6 November 2020

**Kings Park Metal Recovery and Recycling Facility Expansion (SSD-10396)  
Request for Additional Information**

## ATTACHMENT 1

300mm clearance

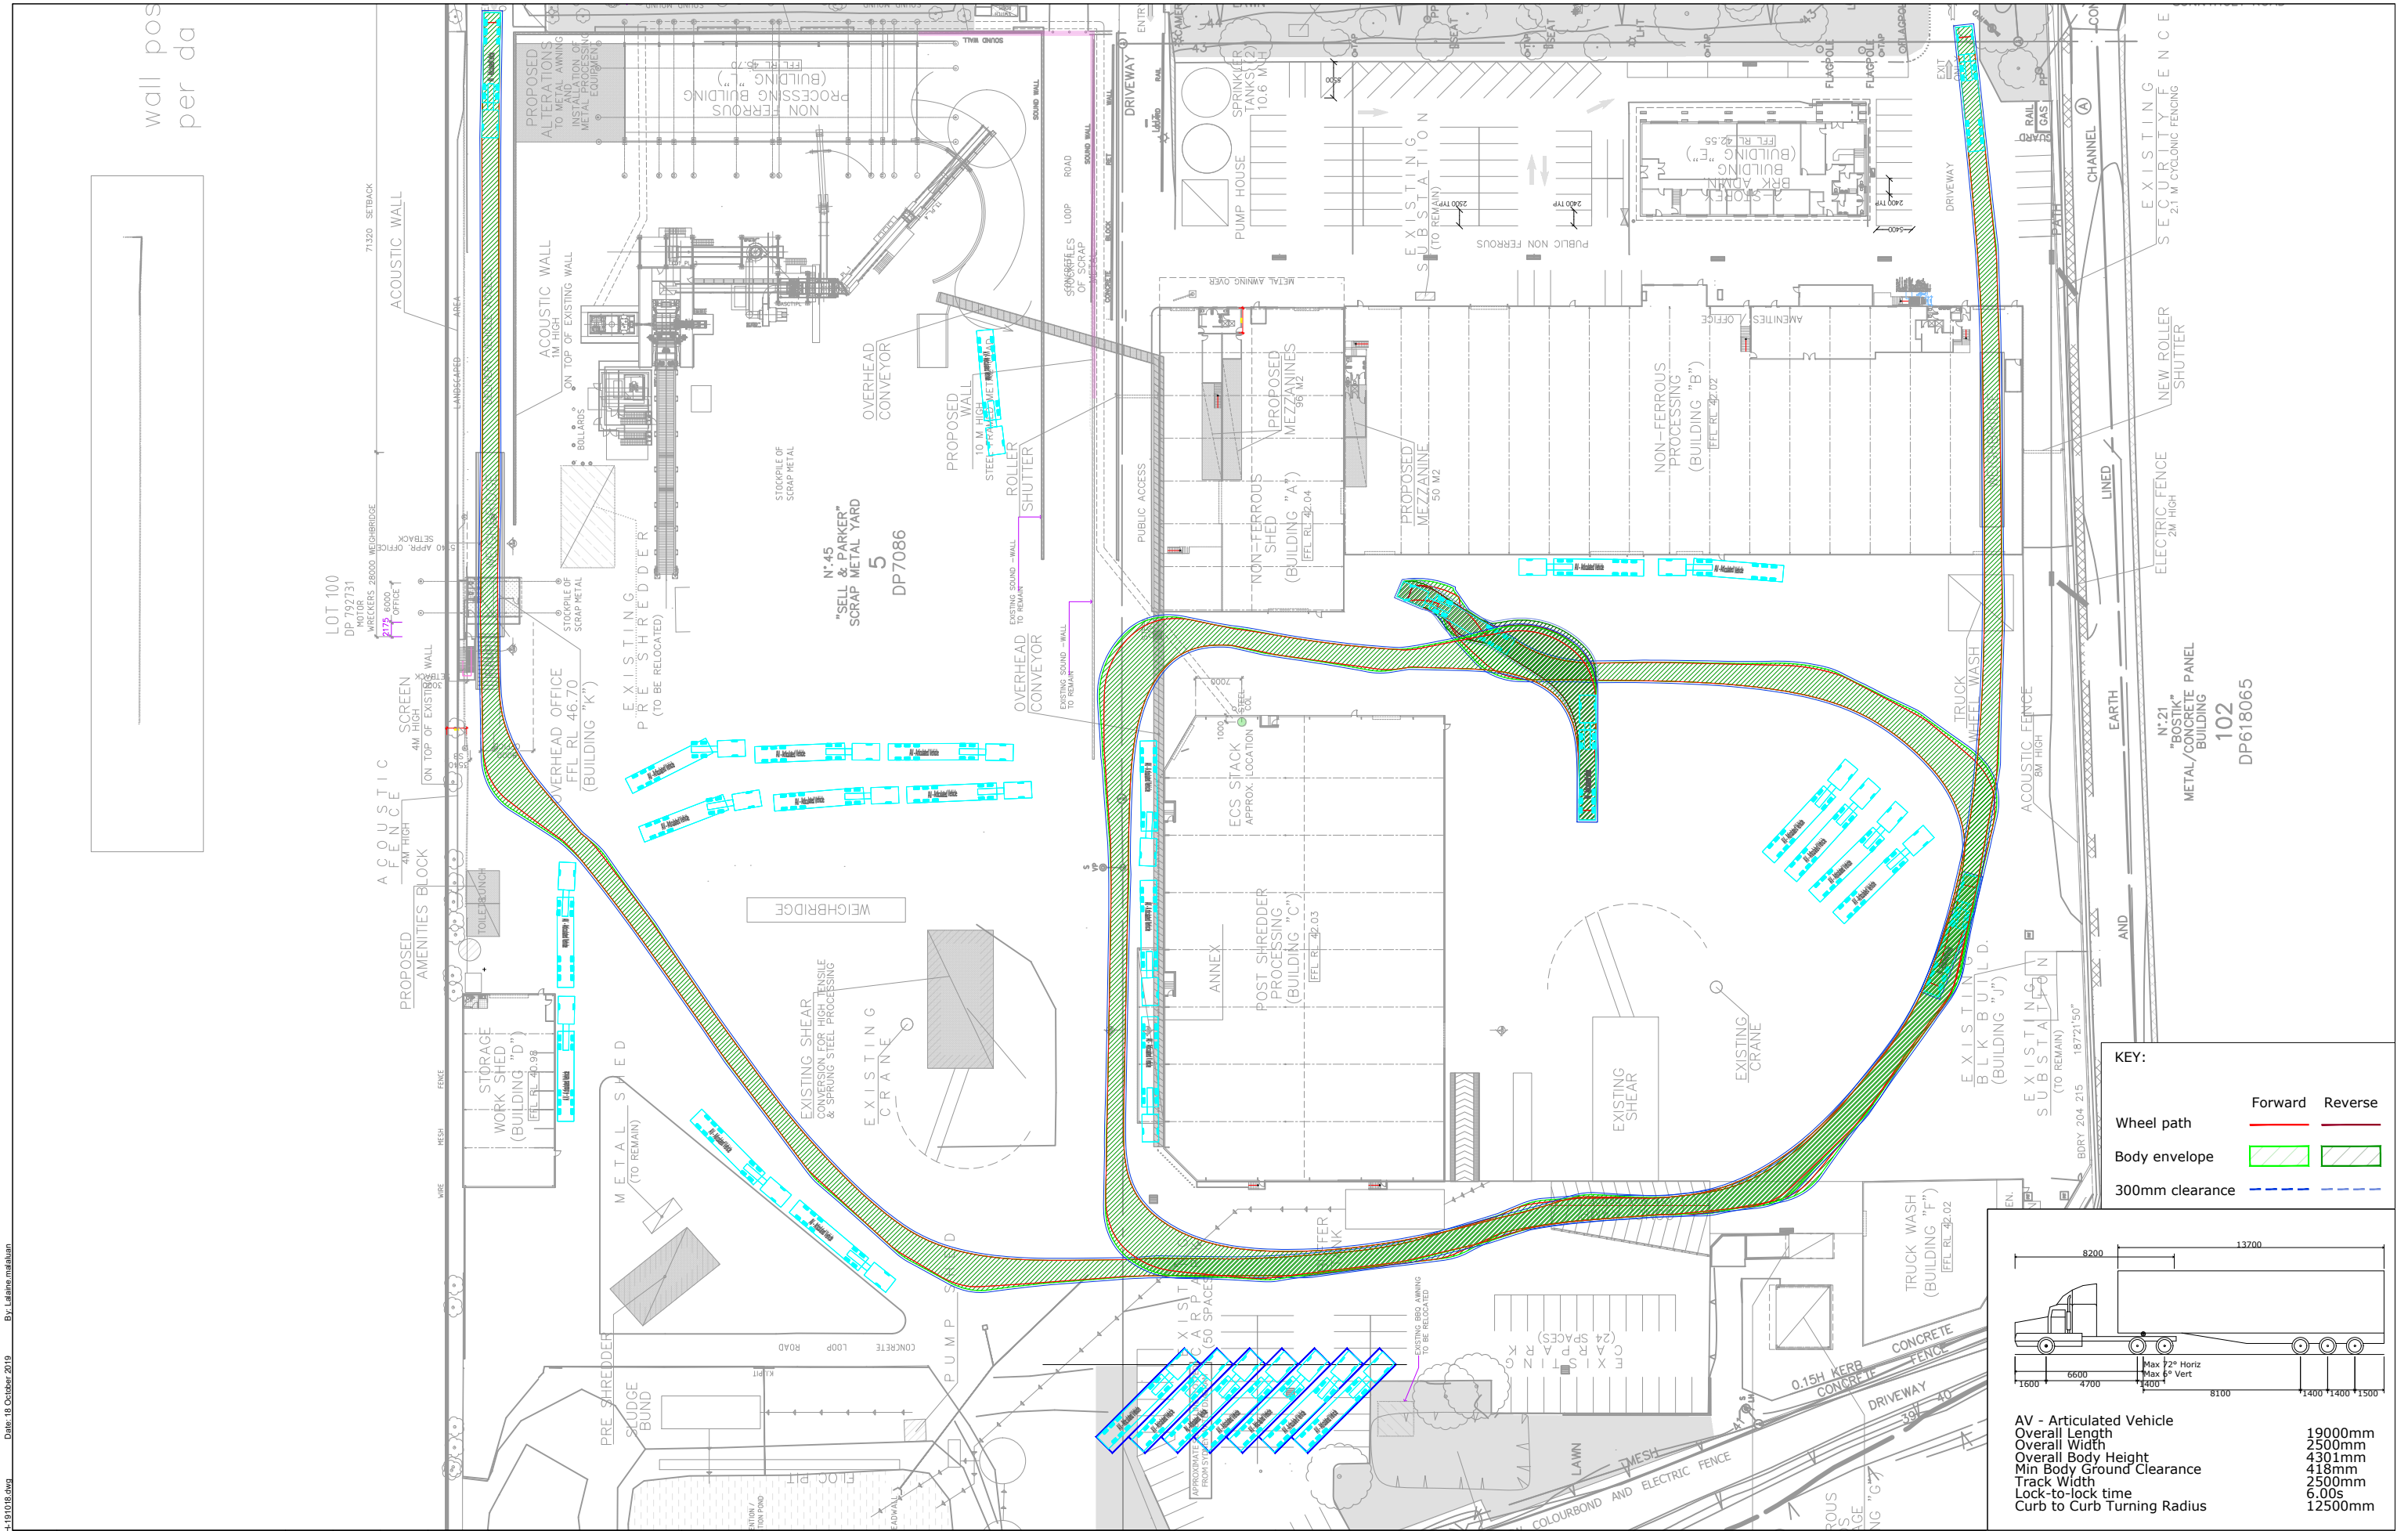
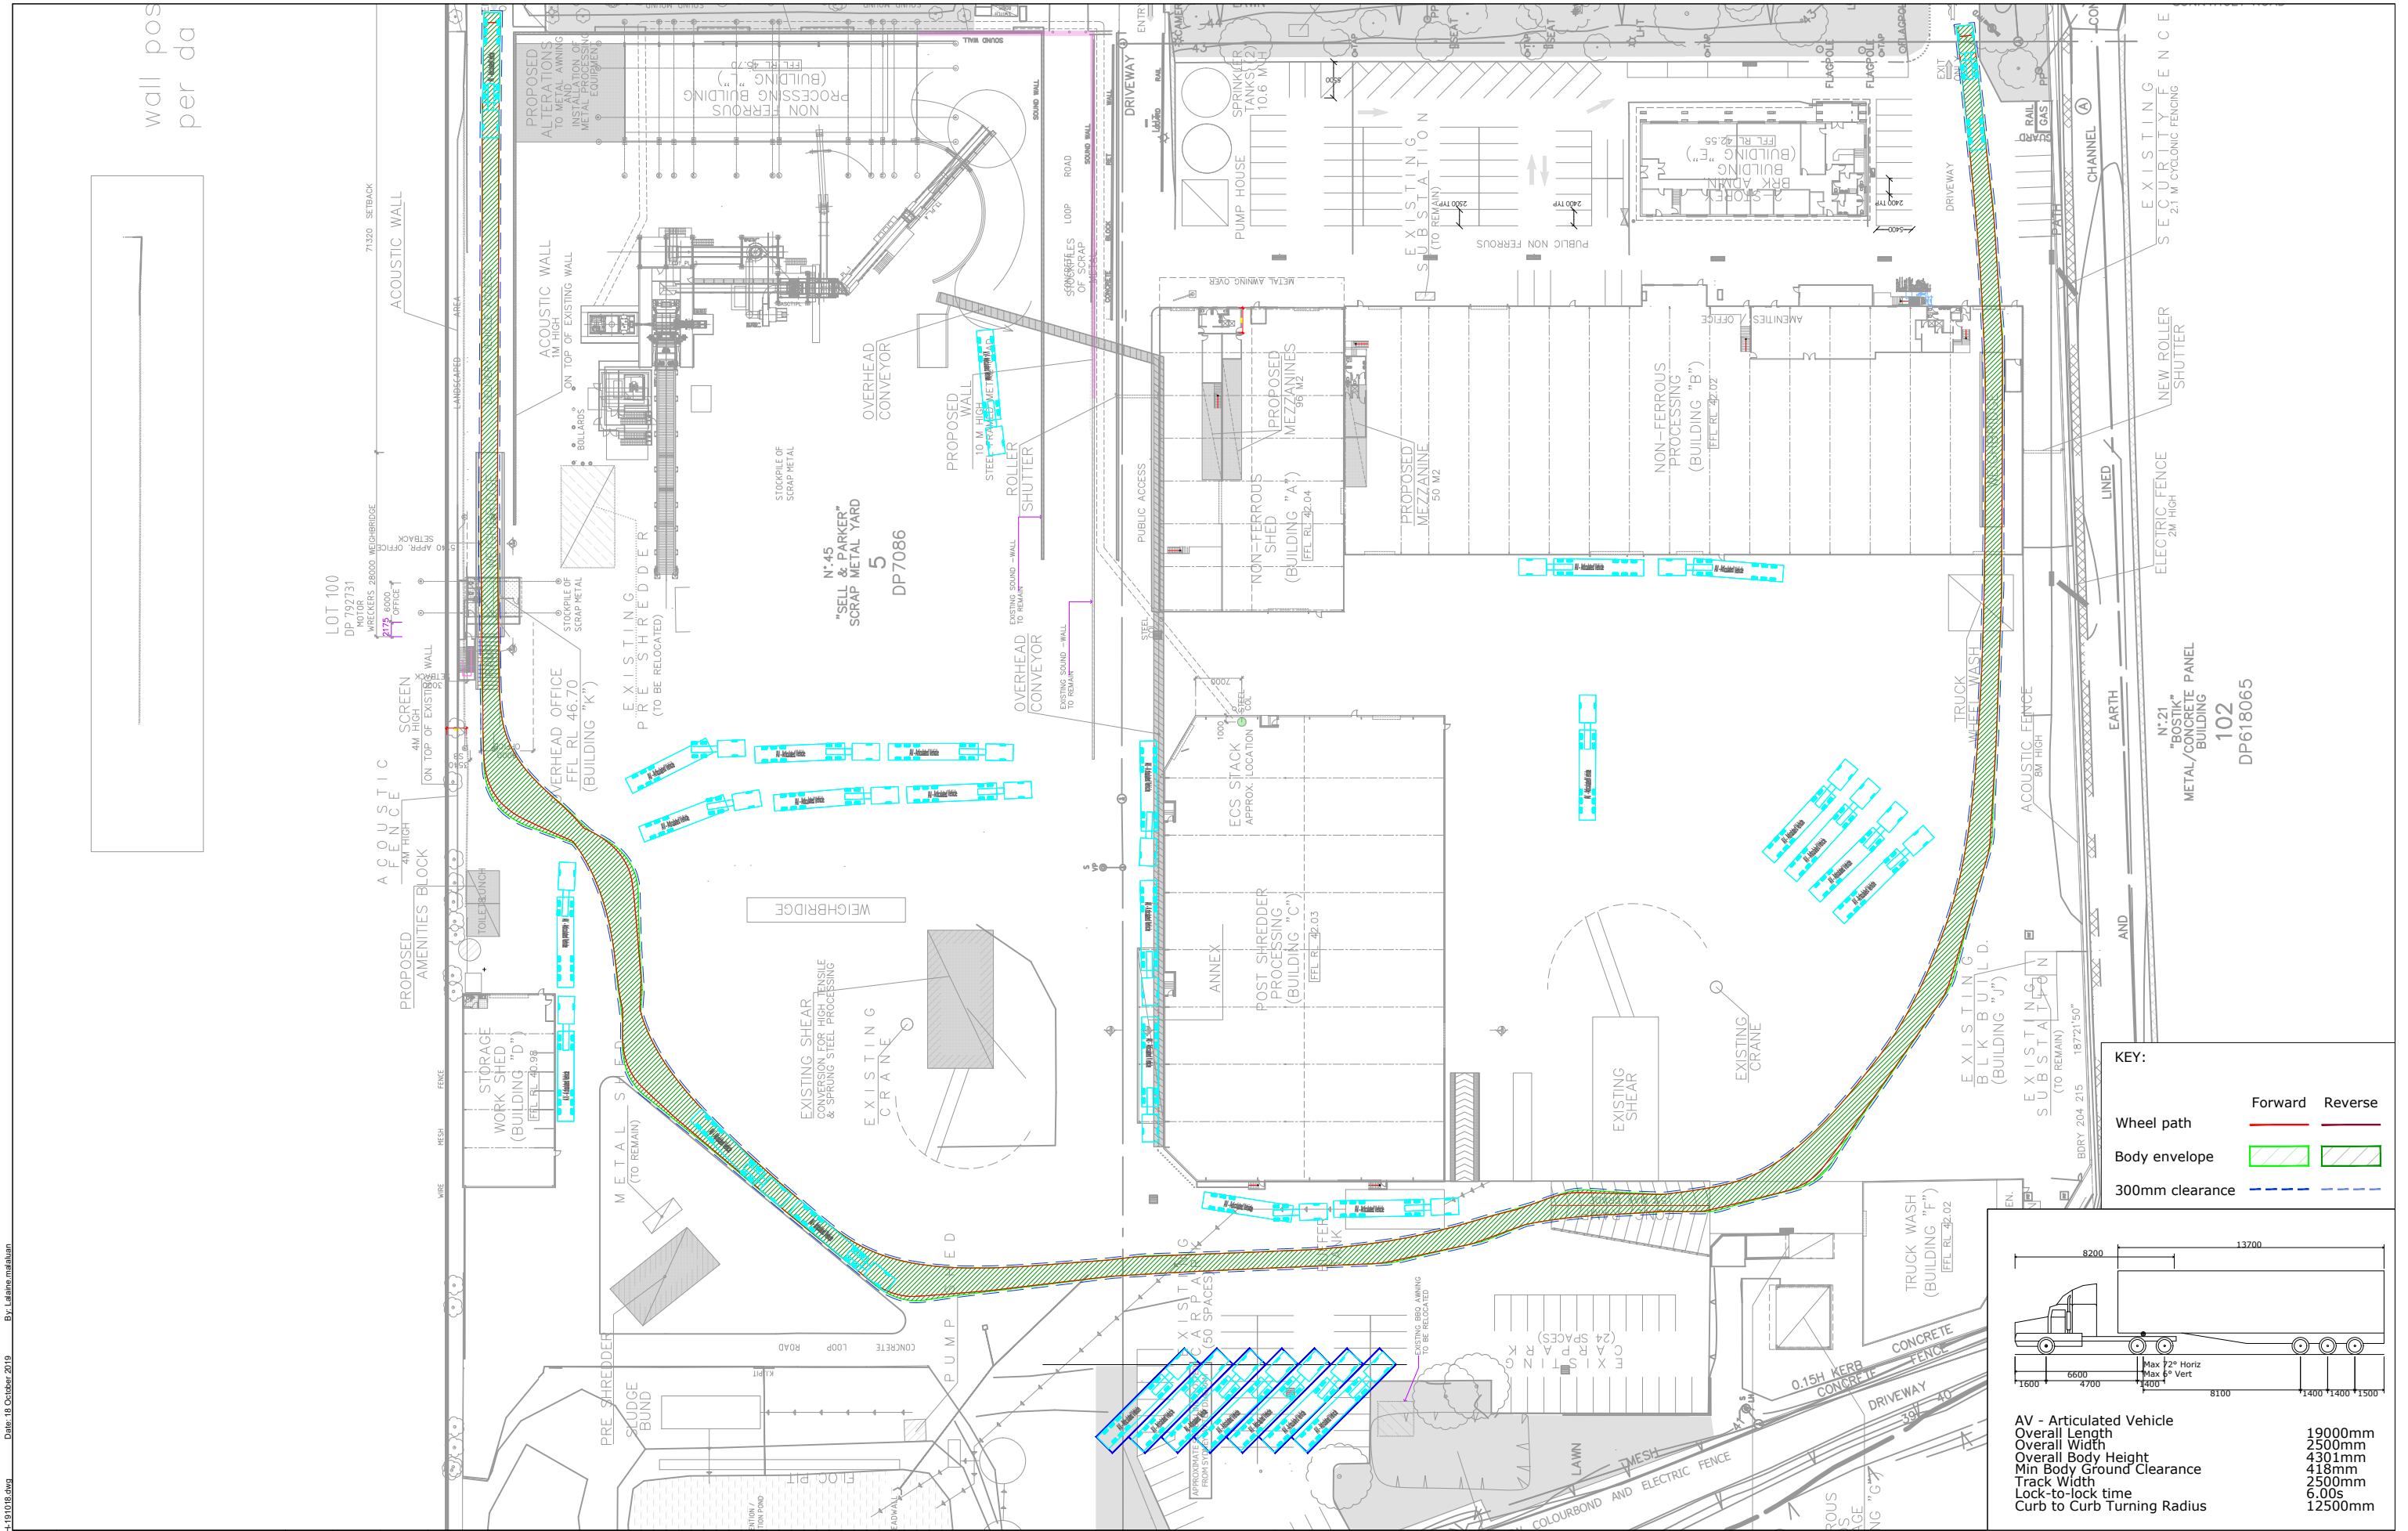
- It is noted the site has three weighbridges: one entry, one exit and one adjacent to one of the shears. Please explain the purpose of the central weighbridge. If its use is associated with the central entry (non-ferrous material), please explain why its use is not shown on the swept path analysis for those vehicles using the central entrance.

- It is noted the assessment identifies peak periods which were used to assess impacts across the scenarios. Please clarify whether these are peak periods for the road network or for the facility.
- It is noted that swept paths have been provided, however, the plans do not include stockpiles. Please update the plans to include stockpiles and ensure the swept path analysis demonstrates that vehicles can safely access the relevant stockpile.
- Table 6.2 in the traffic assessment provides a Stacking Capacity Assessment, however it is unclear whether the number of vehicles accessing the site in an hour represents peak operational periods. If not, please update the table for peak operational periods
